Planning reference: 3/2024/0389

Location: Land to the north of the Chapel Hill site, Longridge

Proposal: Discharge of Condition 14 (surface water drainage strategy), 15 (construction surface water management plan), 16 (surface water drainage operation and maintenance manual) and 17 (surface water verification report) on planning decision 3/2021/1262

I refer to the letter from the Lead Local Flood Authority dated 30th May 2024, in which the LLFA stated was unable to recommend the discharge of Conditions 14, 15, 16 and 17.

PROPOSED SURFACE WATER DRAINAGE LAYOUT

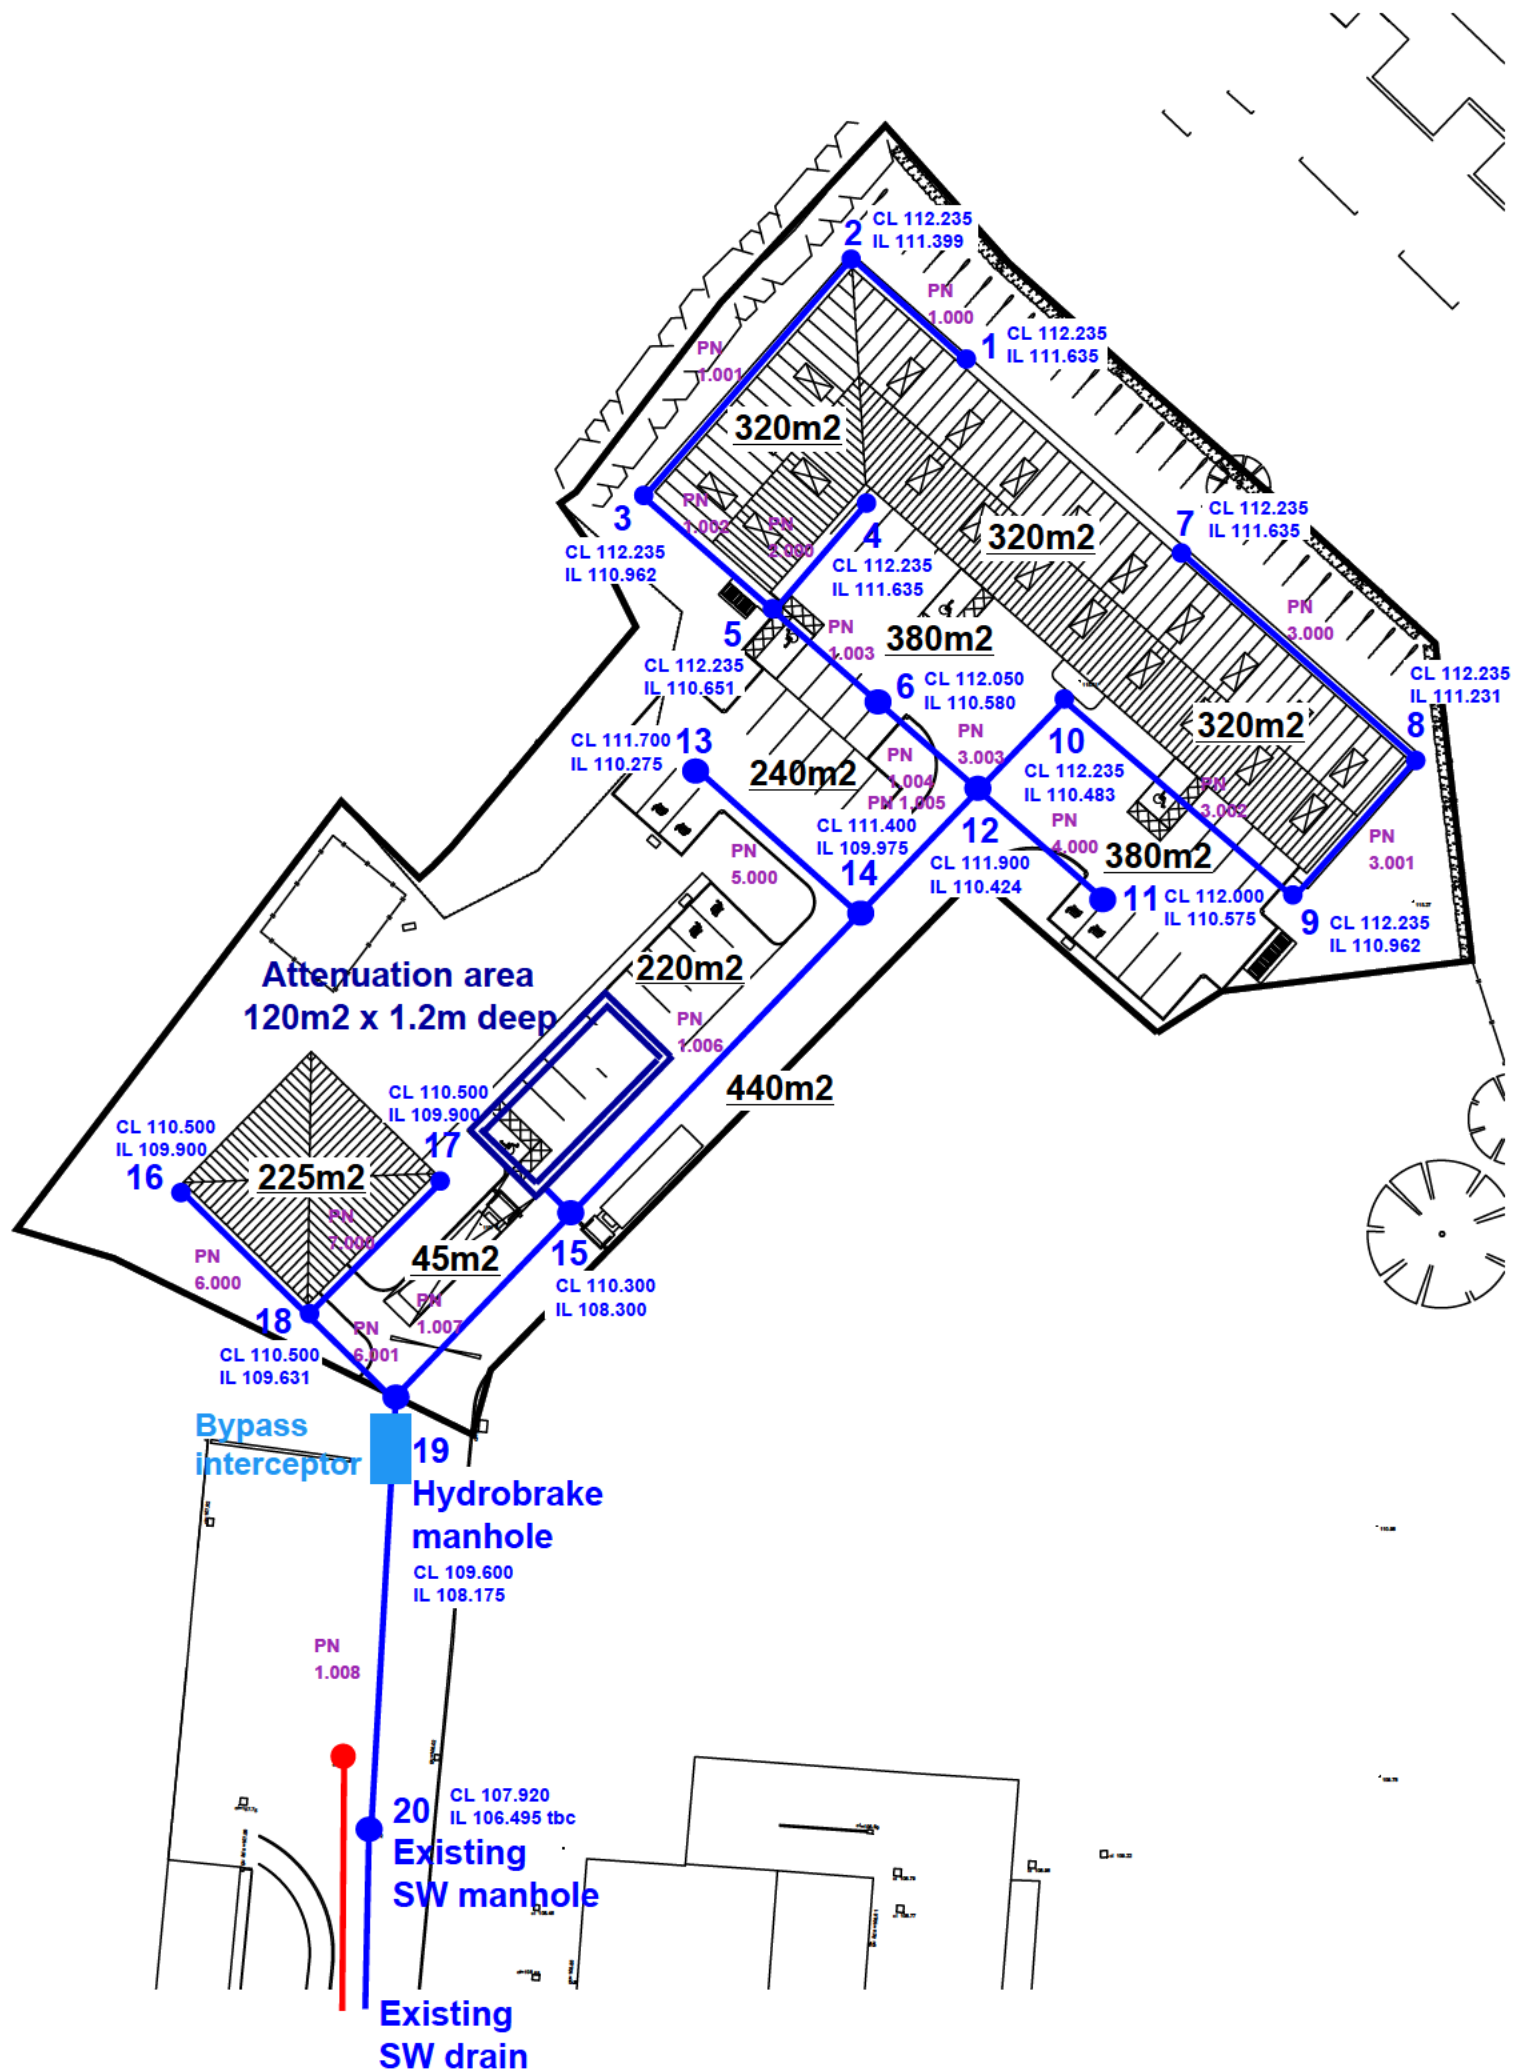
The applicant has failed to provide Finished Floor Levels (FFL) in AOD with adjacent ground levels for all sides of each building and connecting cover levels to confirm minimum 150 mm+ difference for FFL.

Landscape drawings for the site are yet to be produced and do not have a bearing on the drainage of the developed site. A drainage plan showing the exceedance flow route through the site is attached to this letter. With regards to the adjacent ground levels for all sides of each building, cover levels are provided to the manholes adjacent to the buildings along with finished floor levels of the buildings on the drainage drawing included within the report.

Hydro-Brake® Optimum Flow Control including:

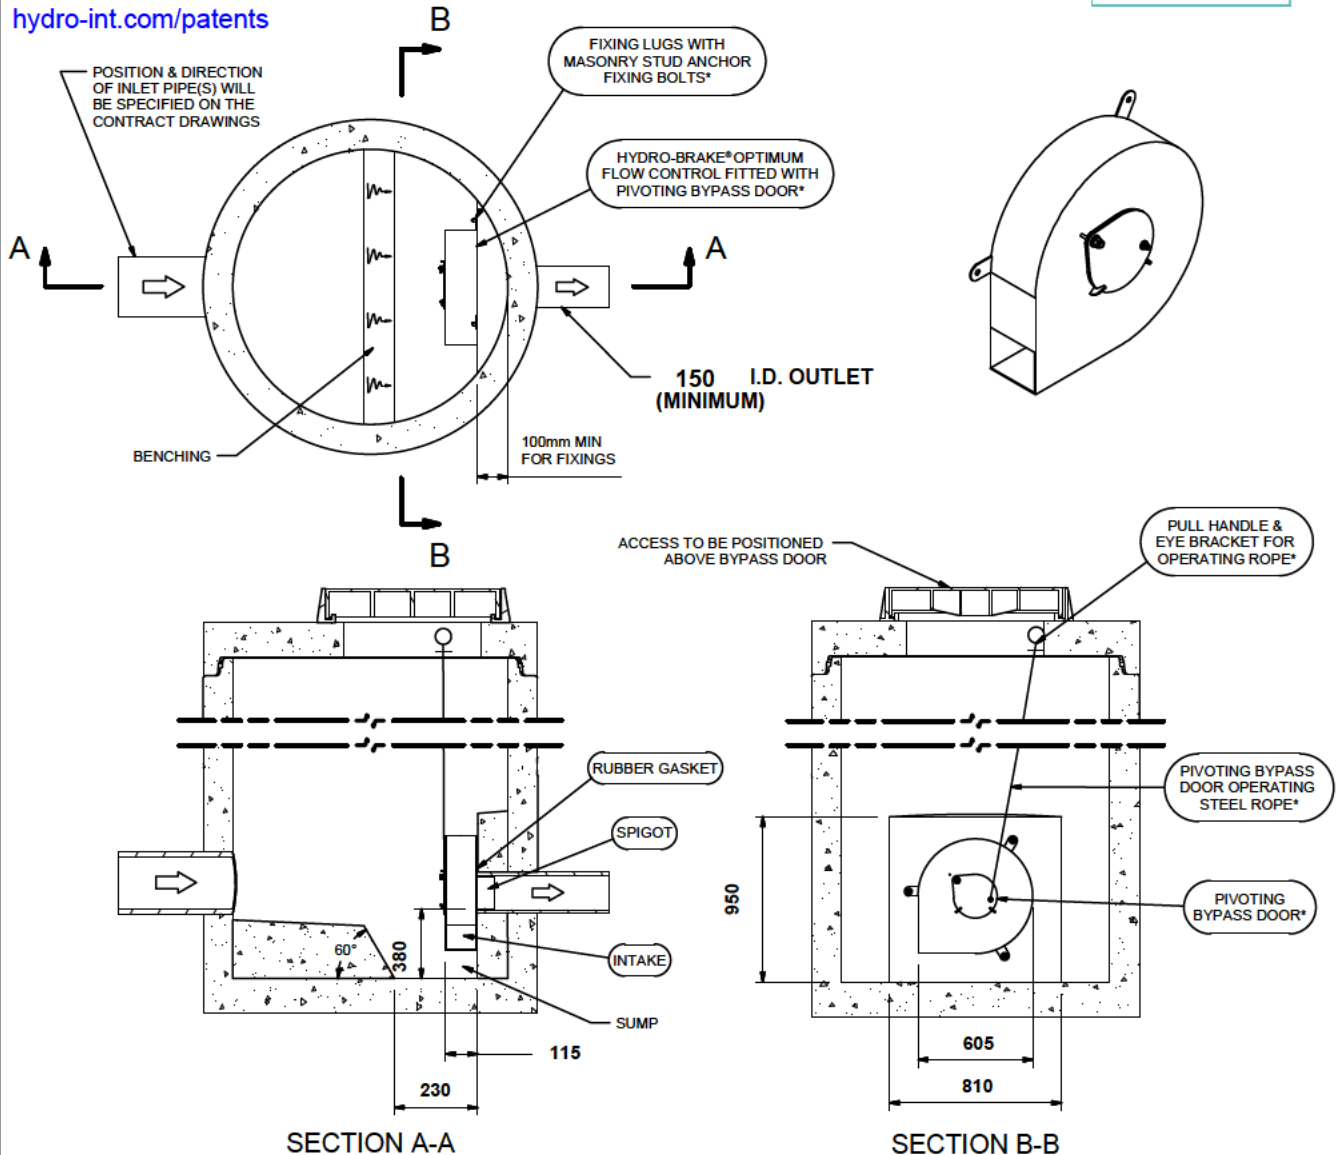
The applicant has failed to provide details of all sustainable drainage components, including landscape drawings showing topography and slope gradient as appropriate.

Response: A detail of the hydrobrake manhole is included within the report submitted to discharge the condition. A typical attenuation storage detail is attached to this letter.
